# **A1 in Northumberland: Morpeth to Ellingham**

**Scheme Number: TR010059**

## **7.6E Statement of Common Ground with The Forestry Commission**

**Statement of Common Ground with The  
Forestry Commission**

Figure 1 - Ancient Woodland Strategy Plan

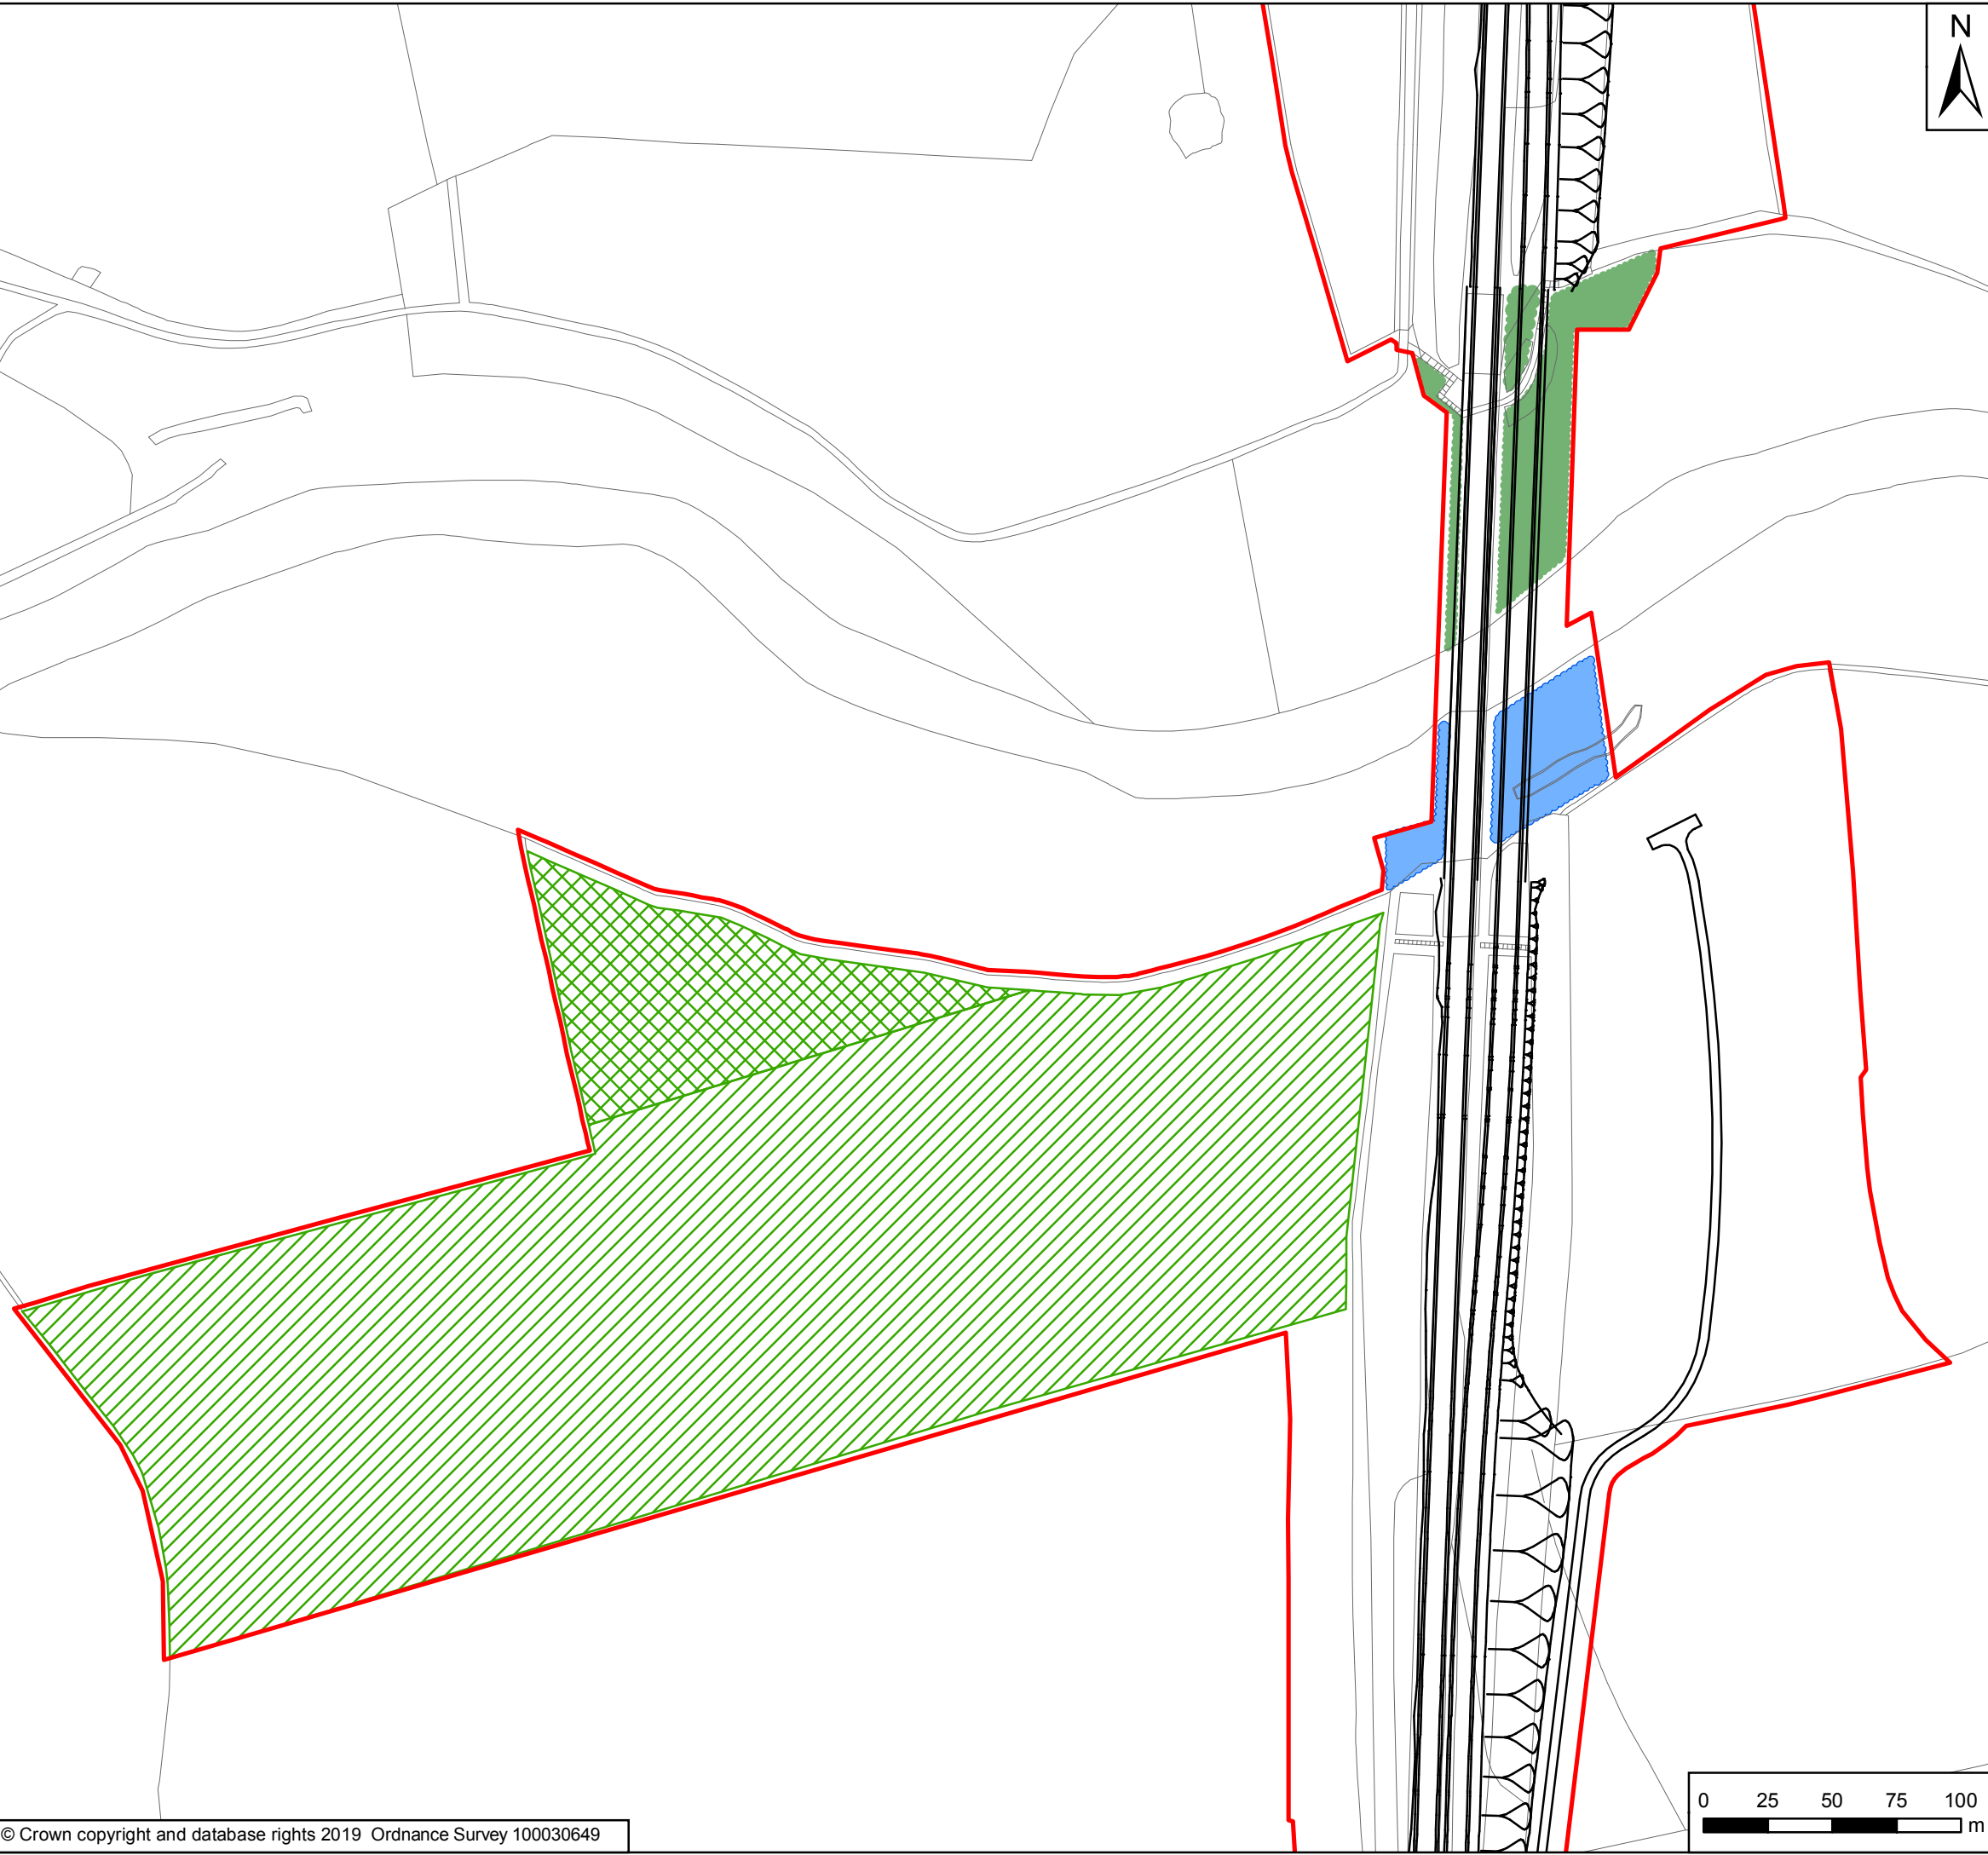
5.		Whilst it is not possible to mitigate for the loss and damage of ancient woodland, an Ancient Woodland Strategy is required to set out how the Scheme will compensate for the loss of ancient woodland.	The Applicant accepts the need to compensate for the impacts of the Scheme on ancient woodland. The Applicant has developed an Ancient Woodland Strategy [REP4-054 and 055], which details mitigation and compensation for the impacts to ancient woodland habitat.	Under discussion.

Item	Document	Forestry Commission Comment	Highways England Response	Status
6		The 12:1 replacement planting ratio that has been agreed with Natural England is sufficient to compensate for the lost ancient woodland only. The Forestry Commission accept this could be an appropriate ratio if the planting is sited in a manner that reflects a landscape scale approach, maximising buffering and linking opportunities.	The Applicant accepts the proposed 12:1 replacement planting ratio. This ratio has been incorporated into the submitted Ancient Woodland Strategy [REP4-054 and 055]. The siting of the compensatory planting has been considered and located to the southwest of the area impacted. This location has been chosen as it is contiguous with the impacted ancient woodland habitat, outside of the area that may be impacted by increased nitrogen deposition from vehicle emissions due to the Scheme and also provides a large area of new woodland that enhances and protects the existing ancient woodland at a landscape scale.	Under discussion.

7.		<p>The Forestry Commission is satisfied that the proposed Ancient Woodland Strategy is appropriate and consider that it appropriately compensates for the impacts of the Scheme on ancient woodland. The Forestry Commission recommends that all planting in compensation and ongoing management is carried out in accordance with the UK Forestry Standard. Also that existing woodlands and other habitats in the local landscape of the proposed development are well considered when developing the proposed compensation.</p> <p>The total loss of woodland for the Scheme as a whole (including 0.96 hectares of ancient woodland as defined in the Ancient Woodland Strategy [REP4-054 and 055]) is approximately 21 hectares. The proposed woodland creation to compensate for this loss is approximately 50 hectares (including the area of ancient woodland compensation planting).</p>	<p>During a meeting on 1 March 2019, Natural England agreed to the approach taken within the Ancient Woodland Strategy. This is recorded in the Natural England SoCG [REP1-029] and is captured in the Ancient Woodland Strategy [REP4-054 and 055] submitted with the DCO application.</p> <p>The submitted Ancient Woodland Strategy would be secured through measures A-L6, A-B3, A-B42, A-B43, A-B44, SW-L1, and SW-B6 of the Register of Environmental Actions and Commitments contained within the Outline Construction Environmental Management Plan (Outline CEMP) [REP7-008 and 009] (and as updated at Deadline 10) and Requirement 5 of the draft DCO [REP6-010 and 011].</p>	Under discussion.
